From: Nicholas Wood [REDACTED]
Sent: 24 July 2015 11:30
To: Anita Gardner
Subject: Re: R/125/L and R/124/5/HH - Annexes at Elm Farm, Rustington

D4 - East Elevation

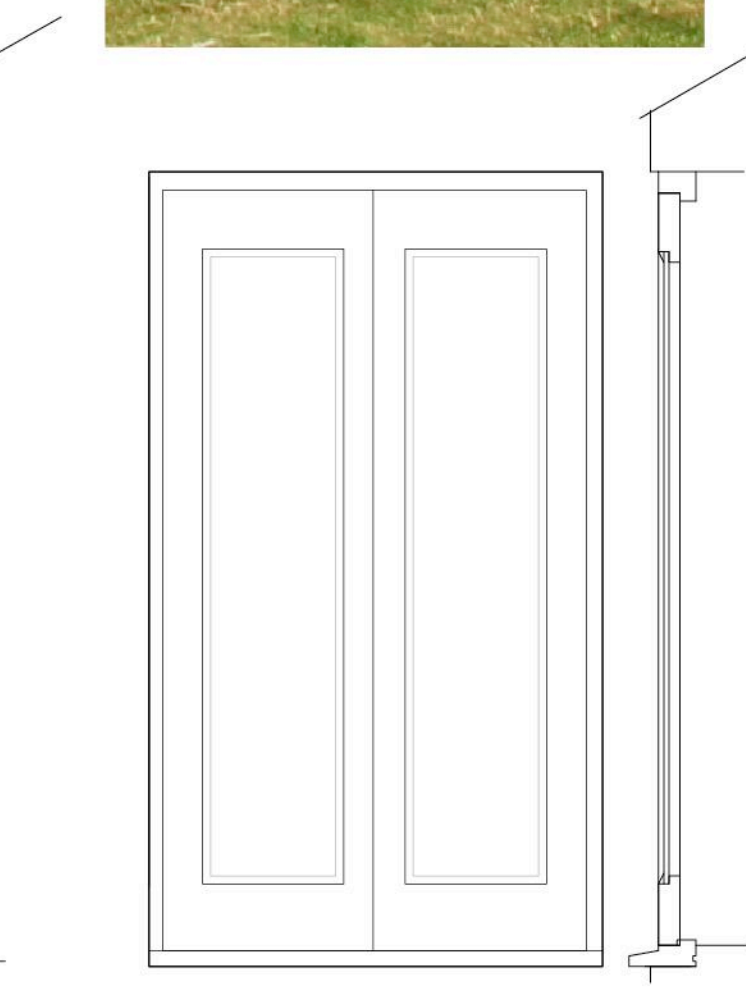
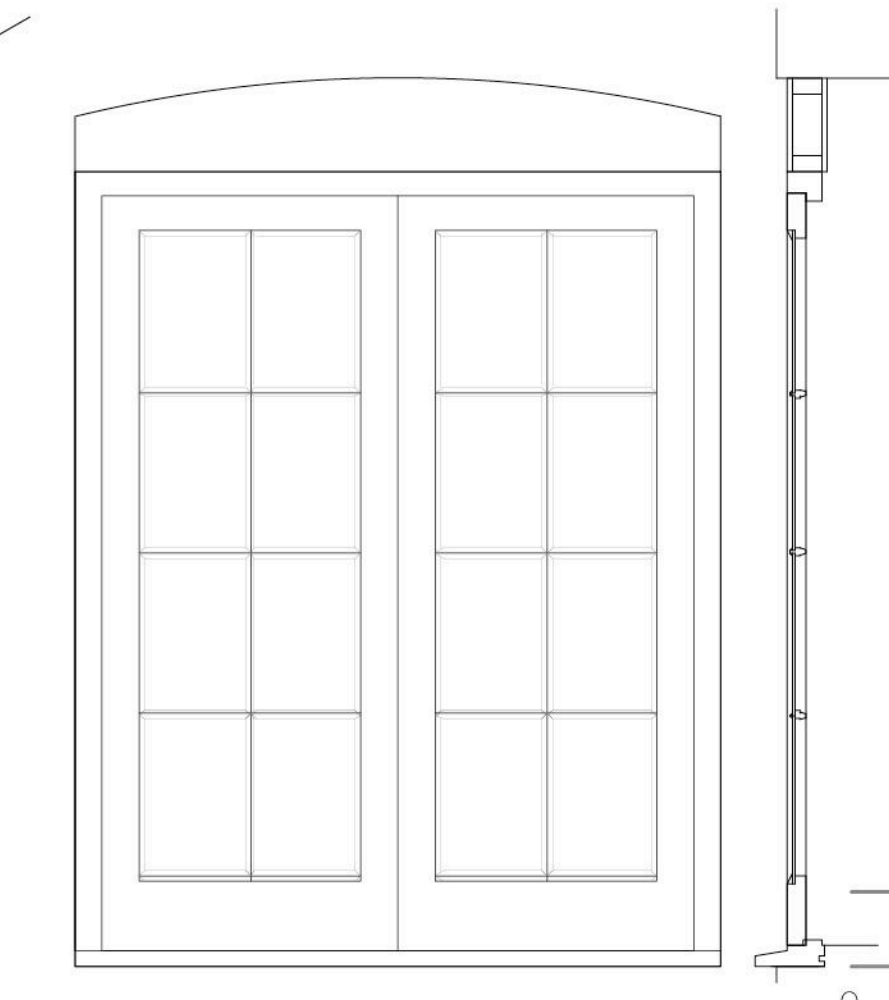
I have discussed the above application with Dr Wightman today. He has stated that whilst the scheme is acceptable he would recommend amending the design of the proposed French doors in the east elevation. These would appear more sympathetic with three horizontal glazing bars to mimic the front. In addition I am concerned that the annexe would be completely separate from the existing dwelling and would I prefer to see a link retained at ground floor. I would suggest that the provision of new studwork to this door is deleted and the existing door is simply fixed shut.

Drawing 102A - East Elevation french doors - 3 horizontal glazing bars added
Drawing 05B - note amended regarding the link door and plan amended
Drawing 08A - East Elevation amended to reflect the additional glazing bars as 102A
